From: Joyce Christie <Joyce.Christie@Cherwell-DC.gov.uk>
Sent: 04 November 2020 11:41
To: Gemma Magnuson <Gemma.Magnuson@cherwell-dc.gov.uk>
Subject: RE: Applications: 20/00947/F & 20/00948/LB Temple Mill, Sibford Ferris

Eaves detail:

Photo 10: site proposed site plan showing the area of gravel drainage around the rear and side of the garage.

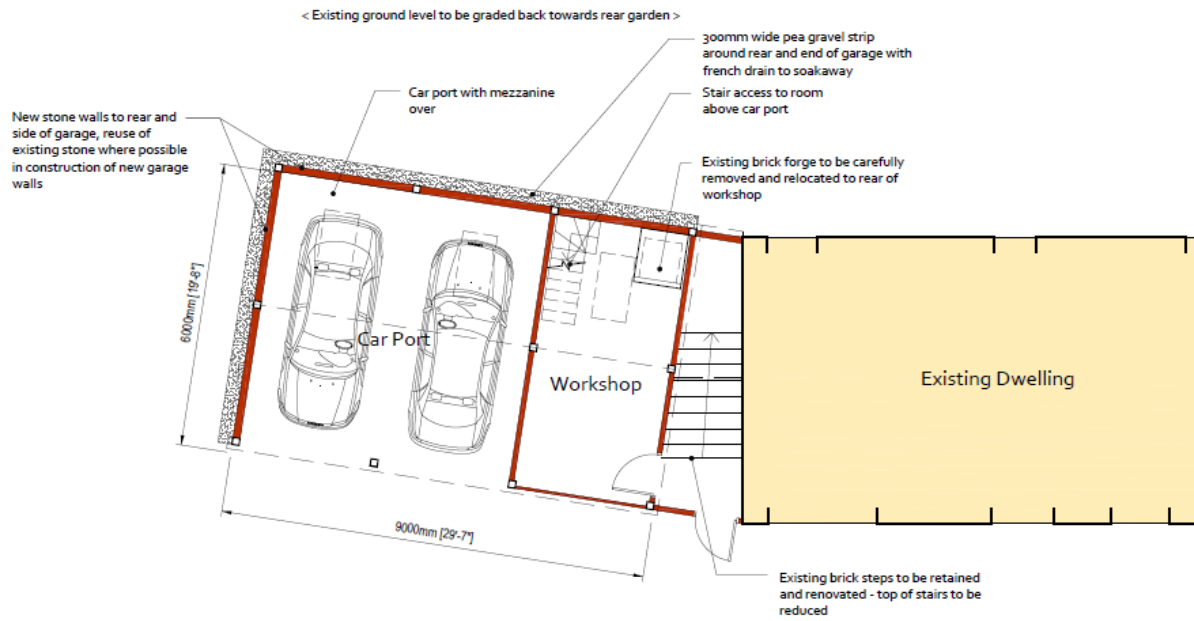
Drainage to the retaining wall/run off the D+A Statement mentions a 300 wide pea gravel strip with French Drain.
 Q. How will the land be retained between the gable and the road the elevation suggests a wall but currently the land is graded down?

Revisions			
Client			
Mr W Sabin			
Project			
Temple Mill, Sibford Ferris, Banbury, Oxon. OX15 5DA.			
Drawing			
Planning Conditions (2) Detail Drawings			
Project Ref	Date	Drawing Number	Revision
DDC 2018-498	August 2018		
Scale	Sheet Size	009	-
1:10	A1

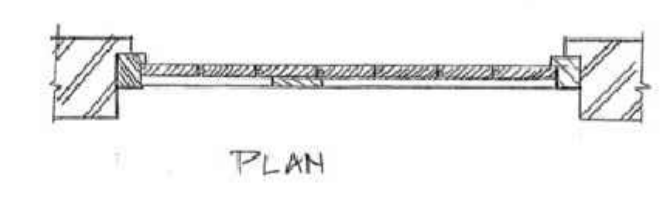
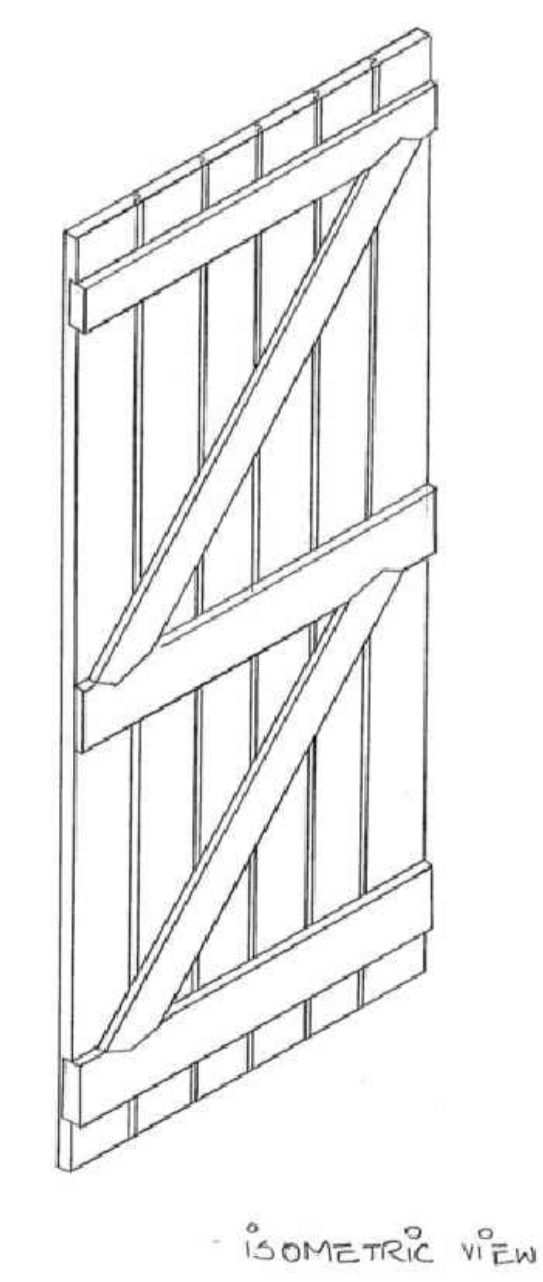
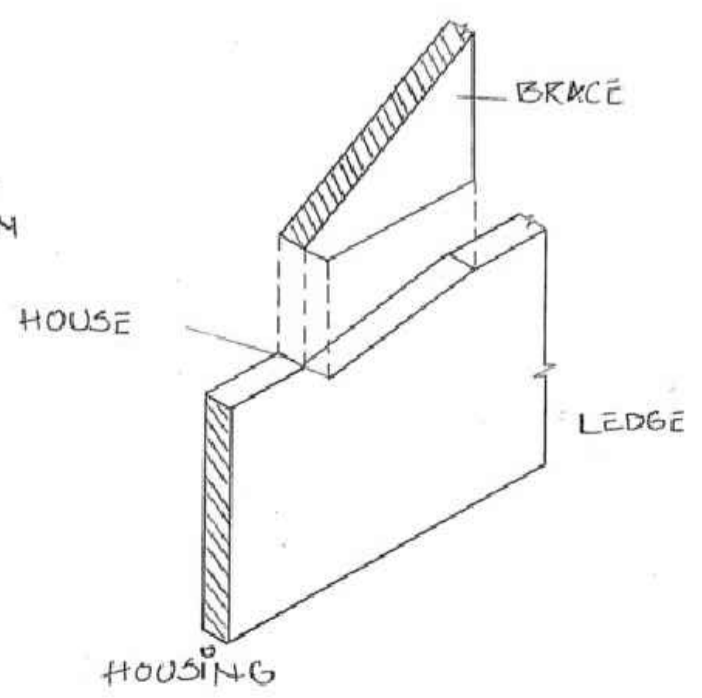
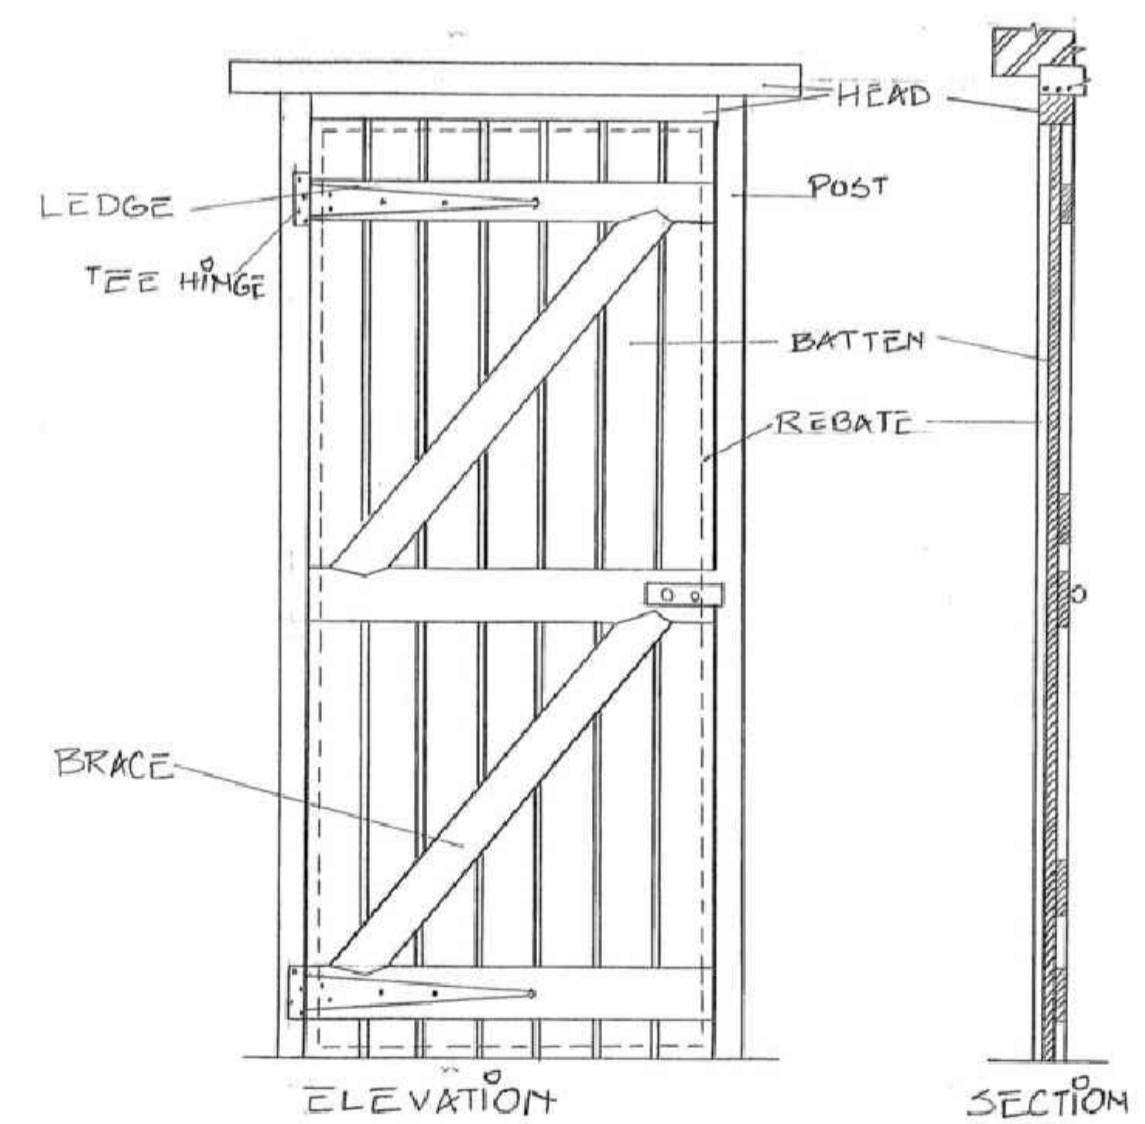
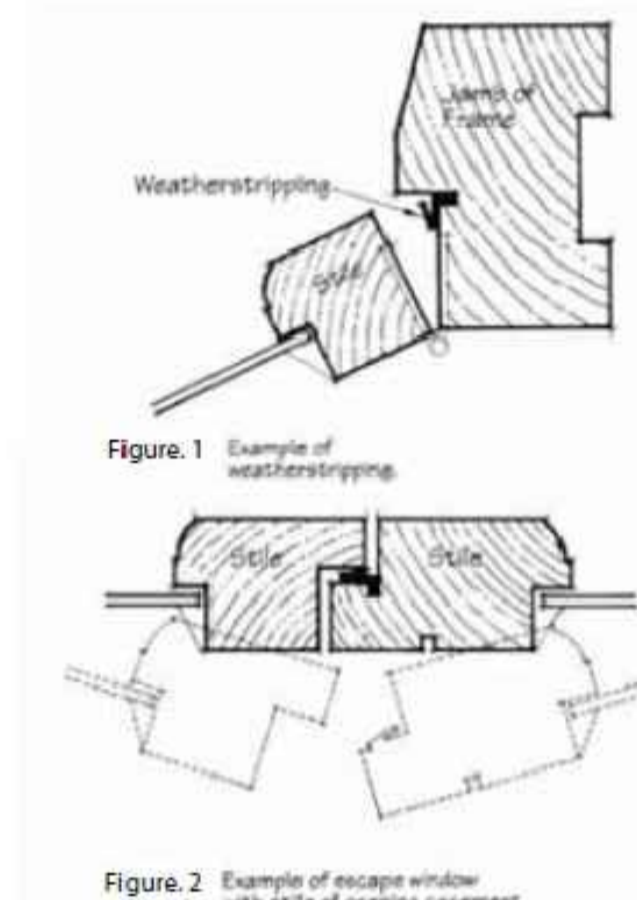
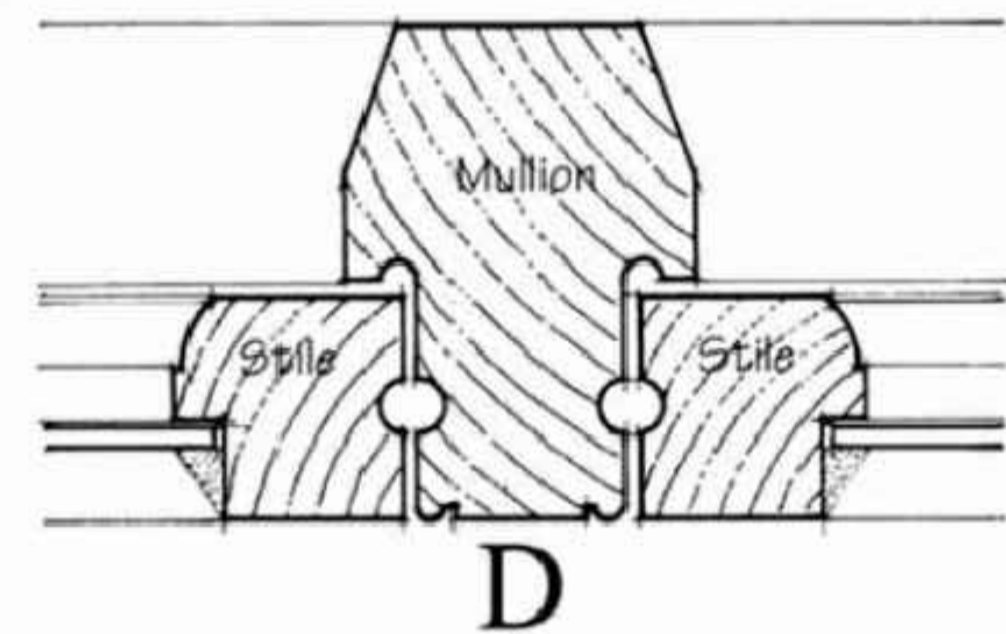
Note says rafter ends exposed but the drawn detail shows a traditional eaves which is preferred. We need confirmation.

Not sure the wall plate position or height/slither of masonry is quite how it will be built.

I expect the joiner will introduce a drip to the cill of the window above the timber cladding/ensure a robust detail where the timber cladding protects the head of the door etc.

Non-traditional cover strip on the garage door is shown on plan but not on the elevation:
 The drawing note suggests it could be applied on the inside – this would be preferable to having it on the outside/for additional protection it may also be possible to lap the meeting stiles of the door (as would be done on a traditional timber window casement without a mullion).

Q. Please check they are using a 'between the rafter' detail rather than 'on top of rafter' detail. Please check the size (I can't find the size in the catalogue) and confirm the rooflight reference number/and if it is hinged at the top.
